From: Carmichael Ian <ian.Carmichael@thamesvalley.pnn.police.uk>
Sent: 30 March 2020 07:50
To: Matthew Chadwick <Matthew.Chadwick@Cherwell-DC.gov.uk>
Cc: Planning <Planning@Cherwell-DC.gov.uk>
Subject: Planning ref: 20/00574/F. Land North of Hill Farm Hill Farm Lane Duns Tew OX25 0JJ.

Planning ref: 20/00574/F. Land North of Hill Farm Hill Farm Lane Duns Tew OX25 0JJ.

Crime Prevention Design Advisor | Oxfordshire | Local Policing | Thames Valley Police

| Drawing Title: | Security Fencing |

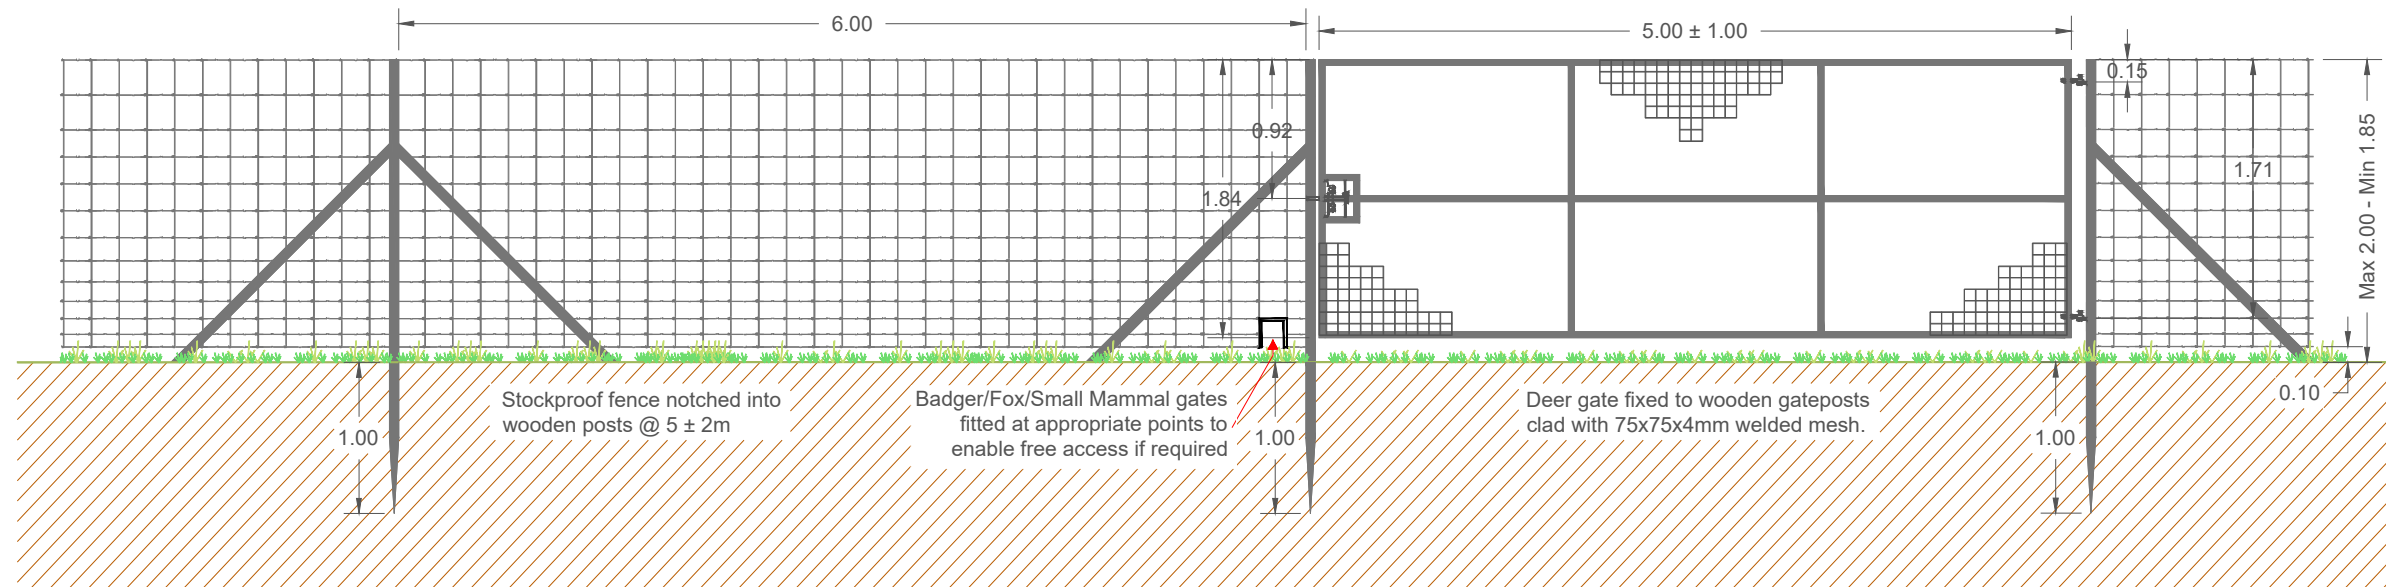
I am pleased to see that a security fence is proposed to protect the installations. This is appropriate, given the size of the proposed site that it could become a high value target for precious metal theft etc. However, I feel the specified fencing does would not be robust enough to prevent unauthorised intrusion. Therefore, I recommend that a higher specification that the requirements of LPS1175, Issue 8, B3, is used instead and that the applicants also incorporate a monitored perimeter intruder protection system (PIDS) to work in conjunction with the CCTV already proposed.

The authority may wish to condition that the development achieves the physical security standards recommended.
